Response to Queries raised by the Planning Department in relation to

2025/91279 Kenmore Drive, Cleckheaton

Rebuttal to Neighbour Objection – Planning Application [2025/70/91279/E]

**PLANT & ASHP ENCLOSURE
DETAILS**

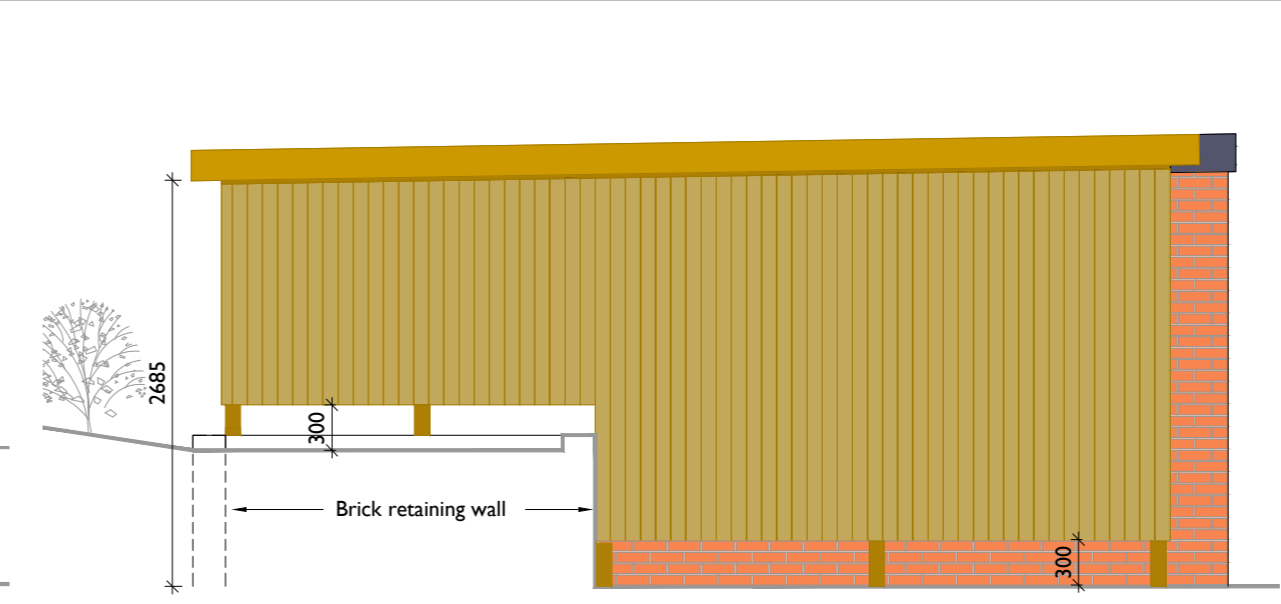
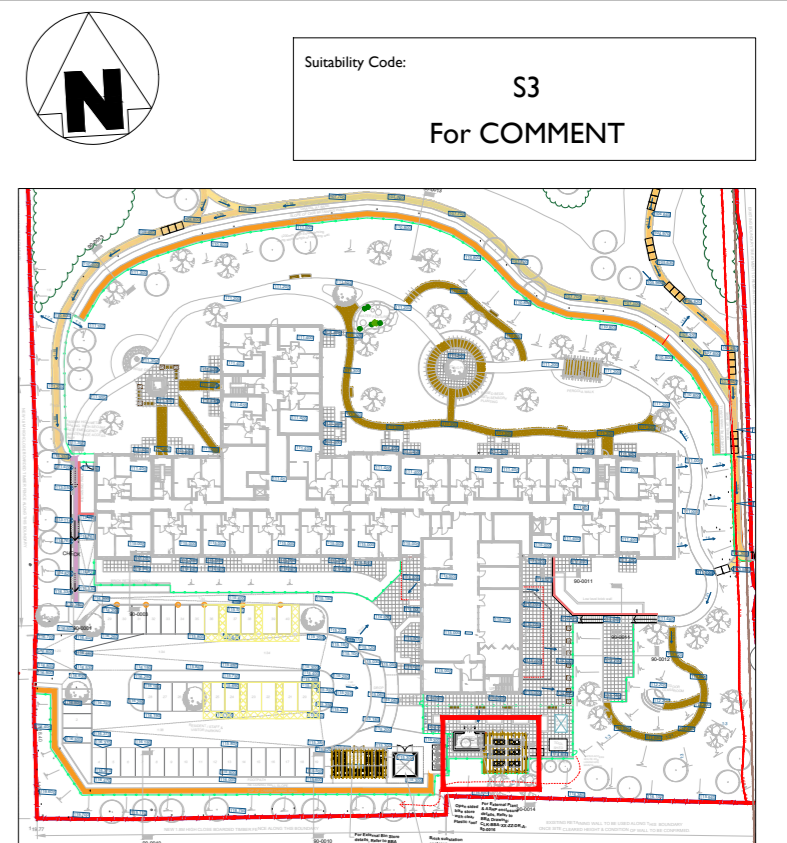
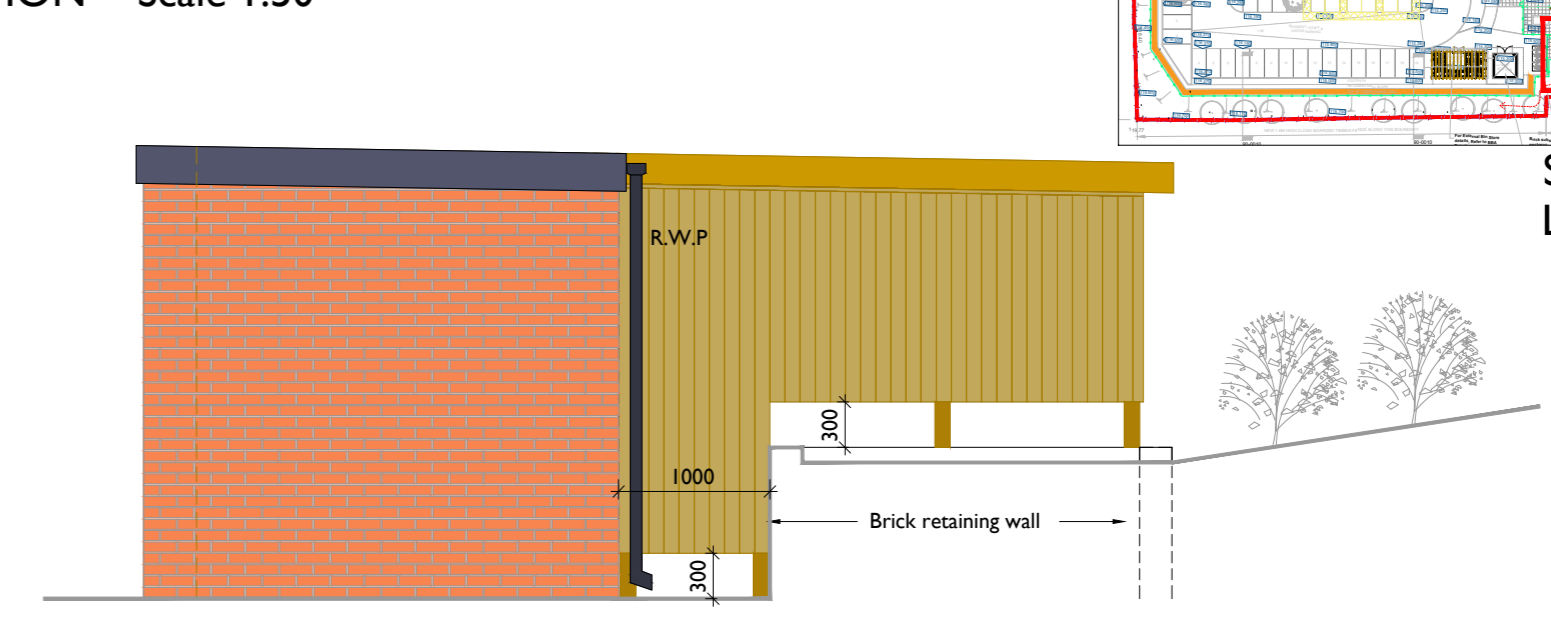
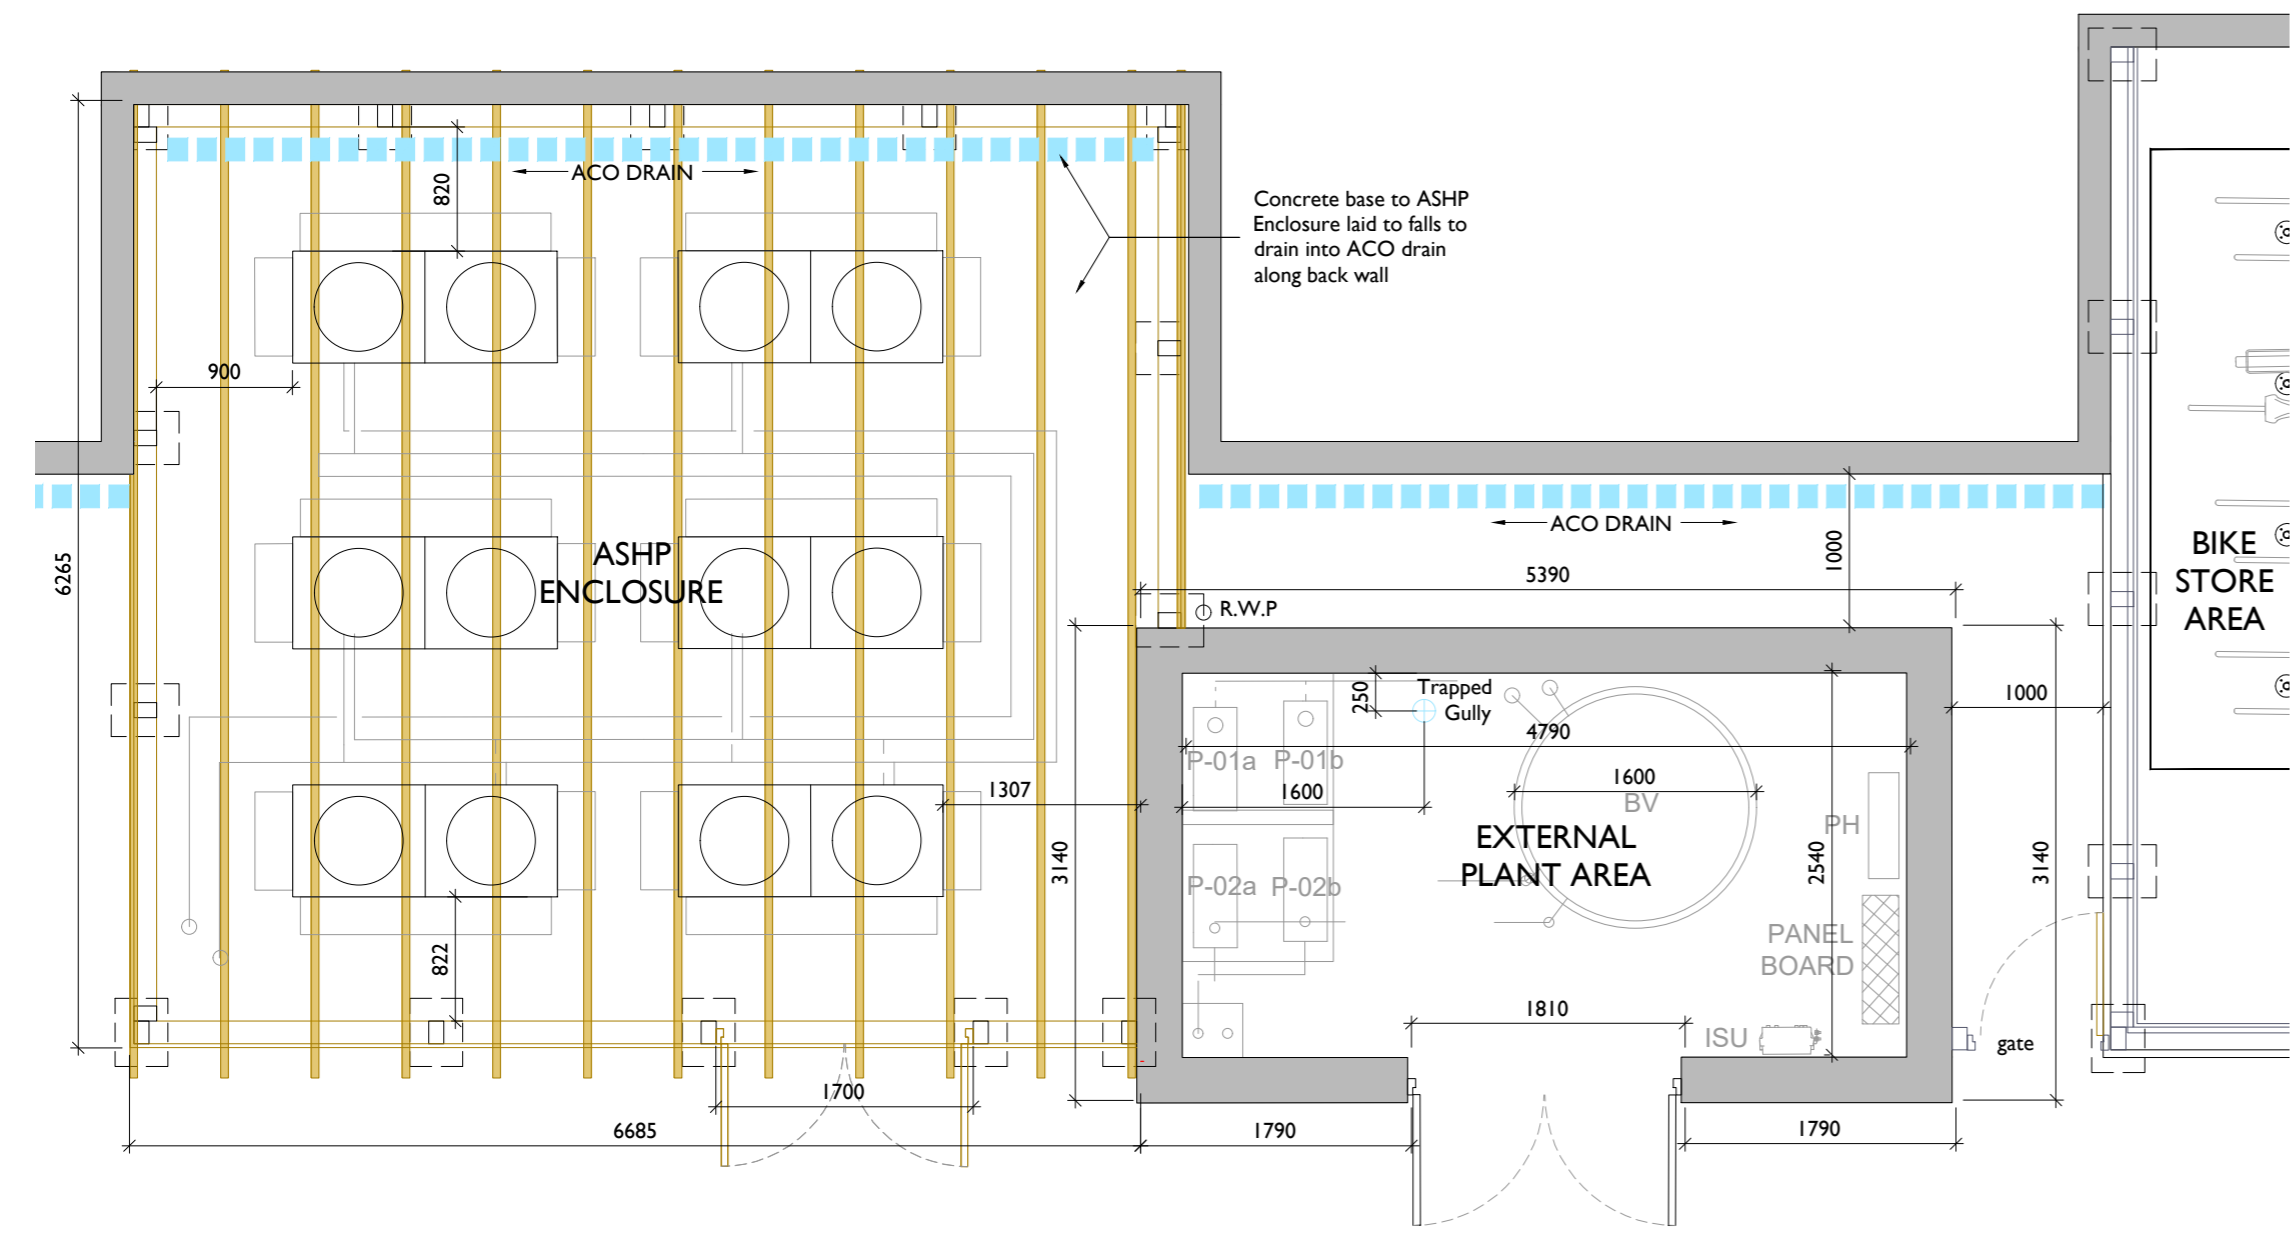
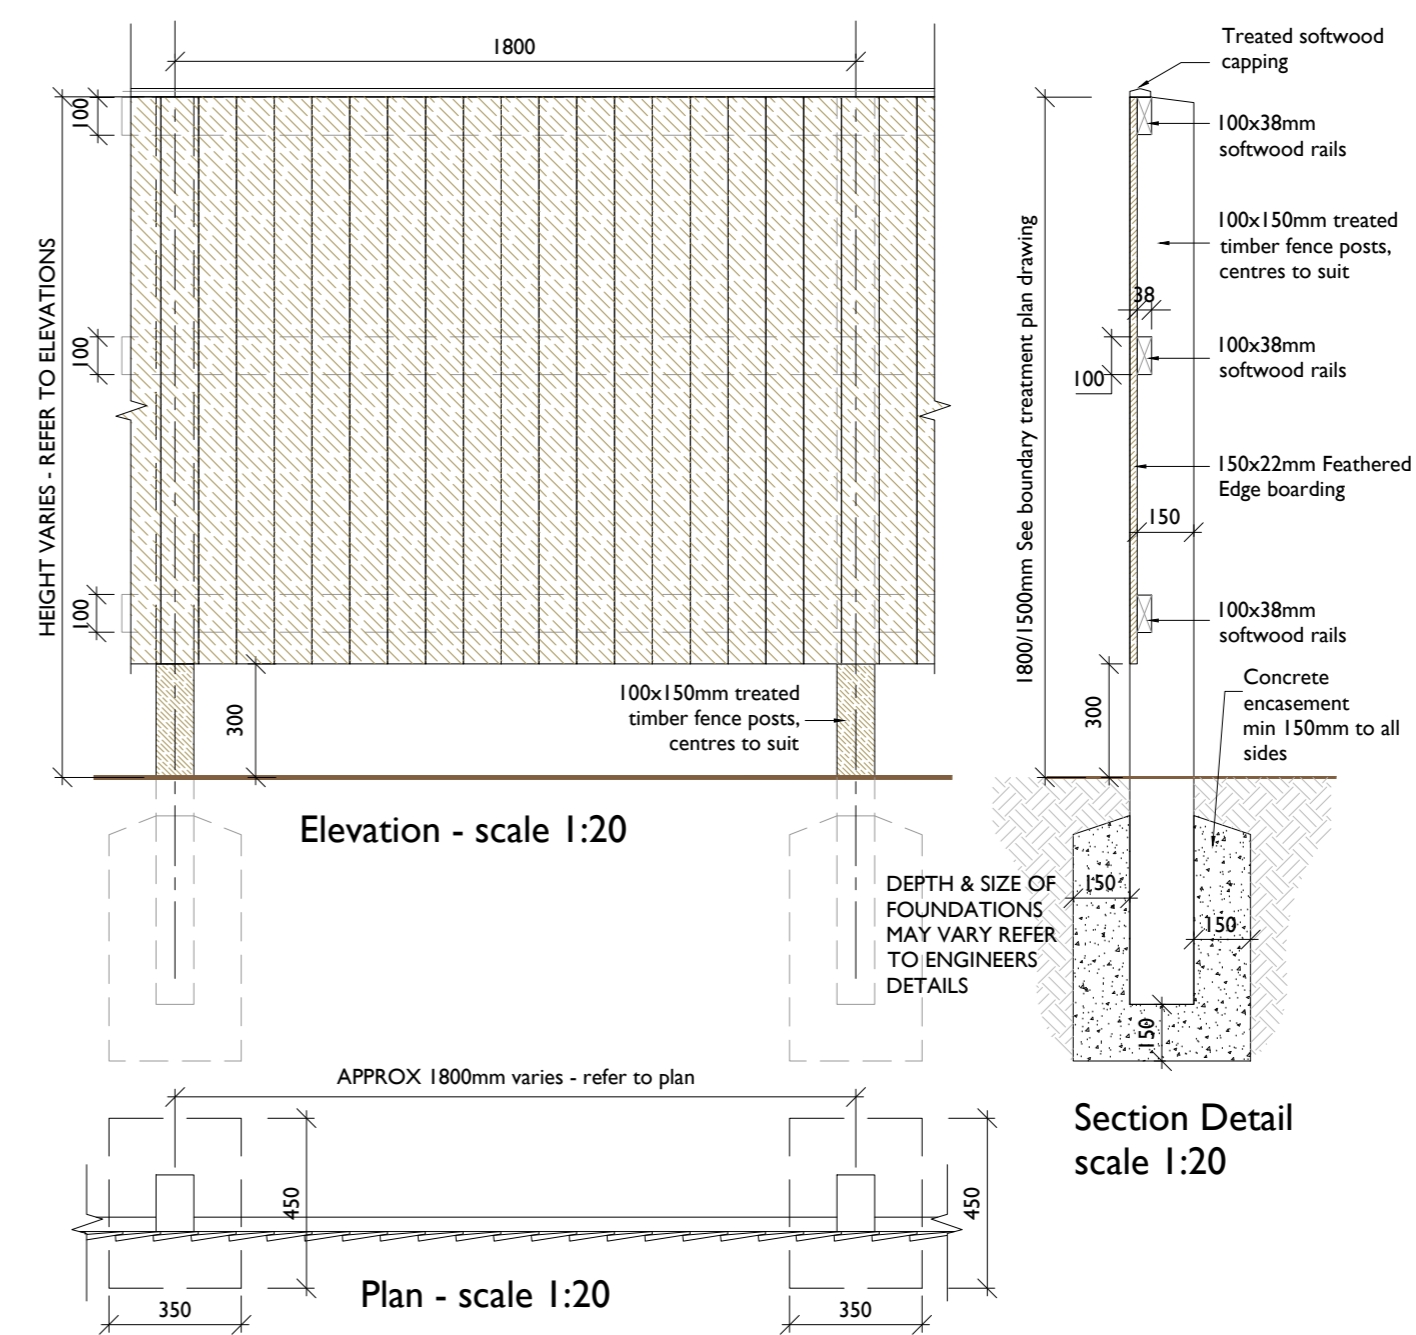
3. Revisions to the design of the compound to add a full roof but partly remove the front wall (facing into the site). This would provide a visual barrier to the neighbouring property and some acoustic protection, whilst leaving space for air circulation.

**Q3.** Revisions to the design of the compound to add a full roof but partly remove the front wall (facing into the site). This would provide a visual barrier to the neighbouring property and some acoustic protection, whilst leaving space for air circulation.

This is not possible at the current height and would require the roof to be raised to approximately 4m tall and widen the compound by 2m we would then need to consider the Health and Safety/Security concern by adding some kind wire mesh fence to allow for the airflow. In addition to this the construction of the compound would need too be enhanced due to the size and height

SECTION THROUGH ASHP ENCLOSURE AND ADJACENT PROPERTY - Scale 1:50

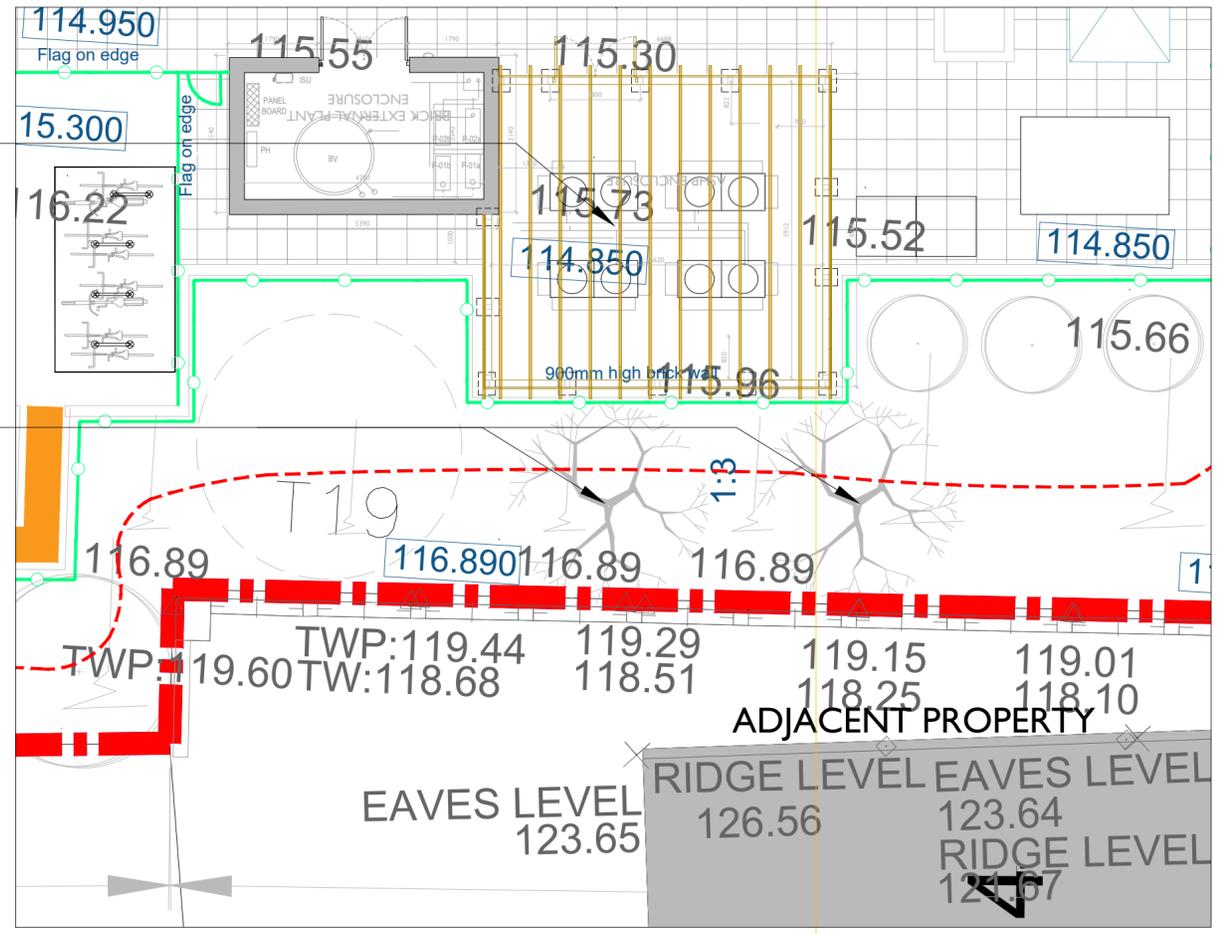
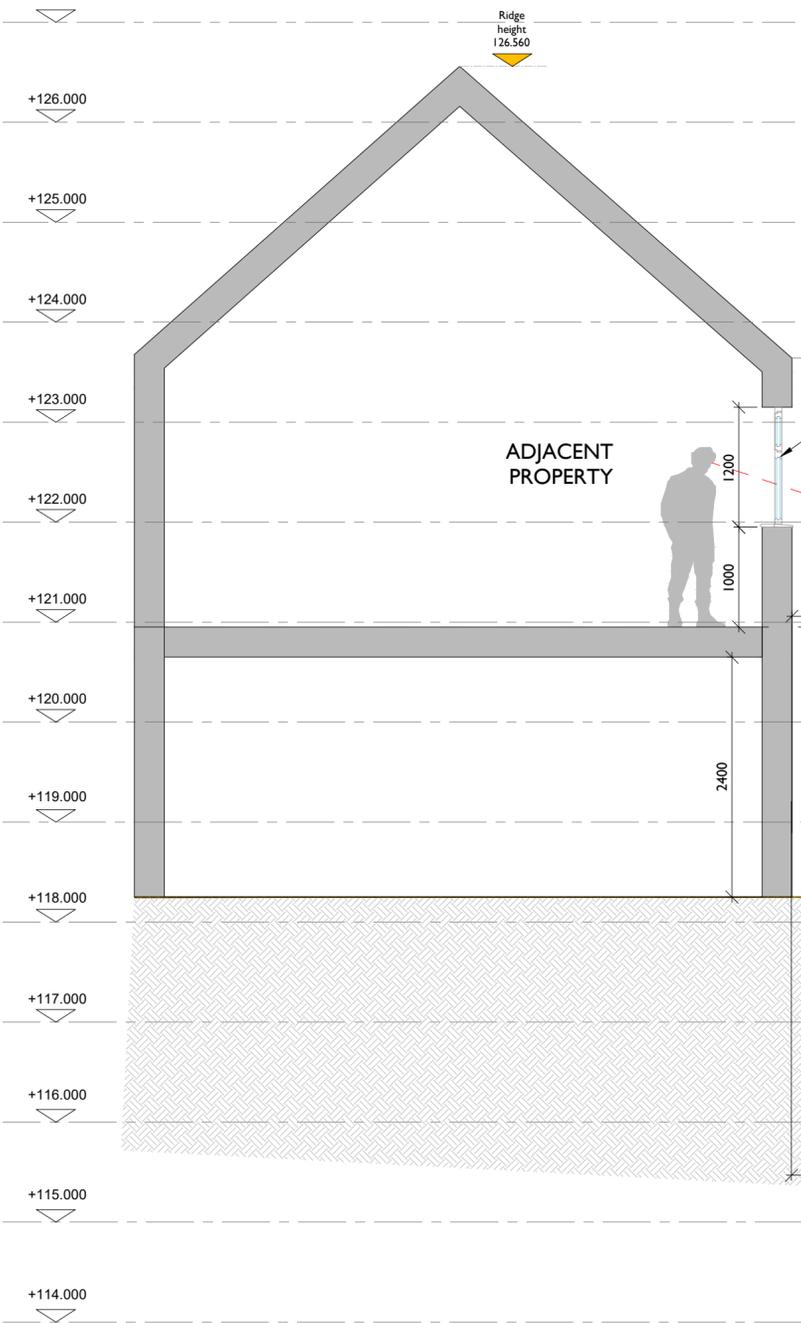
2. Further explanation of the reasons why you conclude mitigation Option 1 (to site the compound at least 30m from any NSR) is not viable. The bullet points in the grey box on the plan provided largely indicate maintenance implications, and whilst there is no vehicular access beyond the car park, it doesn’t state if equipment is required for the routine daily checks referred to, and why any necessary equipment for long-term maintenance could not be carried from the car park (officers note there is no direct vehicular access to Site Location 4 either). In respect of plant replacement, what is the expected lifespan of the equipment, would replacement equipment potentially be required in the event of it failing? Any required works to landscaping/services would be a consequence of this proposal rather than a reason to discount this option, and furthermore the compound could likely be designed/screened to avoid any undue detrimental visual impacts. Officers appreciate you have provided a brief list of the reasons for discounting Option 1; however further evidence is required to support the conclusion that Option 1 is not viable.

**Q2.** Further explanation of the reasons why you conclude mitigation Option 1 (to site the compound at least 30m from any NSR) is not viable. The bullet points in the grey box on the plan provided largely indicate maintenance implications, and whilst there is no vehicular access beyond the car park, it doesn't state if equipment is required for the routine daily checks referred to, and why any necessary equipment for long-term maintenance could not be carried from the car park (officers note there is no direct vehicular access to Site Location 4 either). In respect of plant replacement, what is the expected lifespan of the equipment, would replacement equipment potentially be required in the event of it failing? Any required works to landscaping/services would be a consequence of this proposal rather than a reason to discount this option, and furthermore the compound could likely be designed/screened to avoid any undue detrimental visual impacts. Officers appreciate you have provided a brief list of the reasons for discounting Option 1; however further evidence is required to support the conclusion that Option 1 is not viable.

**It is also notable that the original acoustic report submitted by the applicant (now superseded) explicitly recommended that the ASHP units be located away from noise-sensitive boundaries. The updated report offers no justification for adopting a design that brings the ASHPs closer to my home, omitting earlier advice that contradicts the current siting.**

The document referenced as [Plan General \[id 1088901\]](#)  **Size: 4.1MB 09/05/2025 - CLK-BBA-XX-XX-DR-A-91-0001 - ASHP Locations Reviewed** was provided on request to advise the different locations that were assessed for the installation of the external ASHP Compound and its associated plantroom (energy centre). Please be aware the Plantroom/Energy centre Equipment would ideally be installed within the building served however the change to the heating strategy for the apartments came after construction had begun to the Lower Ground Floor and the Ground Floor, after much review it was concluded a suitable location for the equipment could not be found internally so the external plantroom was created adjacent to the ASHP enclosure, which needs to be external.

Under CDM we have a duty to assess the regular maintenance strategy in addition to major plant replacement. This is a consideration when undertaking the process of selecting suitable areas for the installation of plant as can be appreciated, so it is correct to state that the comments provided are mainly around maintenance and replacement.

All these items of plant require a dedicated service plan, most items are bi-annual and carried out by several different contractors in addition to staff fault finding/investigating when things fail and replacement for when repair is not possible, this equipment ranges in weight up to 360kg so access needs significant consideration. The life cycle expectancy of well-maintained non faulty equipment is 10-15 years.

Due to the considerations for access and maintenance it is preferable to allow for vehicular access. Planning Condition No. 4 relates to the car park plan submitted on the 3<sup>rd</sup> December 2020 by the previous contractor and the condition stipulates the number of parking spaces that are to be made available for the project. Upon review it was concluded they could not be reduced to facilitate the additional plant space. However, vehicle access could be taken close to the chosen and current proposed location which would then allow all mechanical loading of equipment and plant via the flat level surface.

We believe this is in reference to Option 1 of the acoustic report and which was 1 of 3 mitigation options. Option 1 (move the compound) is deemed not possible due to the reasons we have stated elsewhere in this document. We have chosen Option 2 with the high fence and acoustic baffles
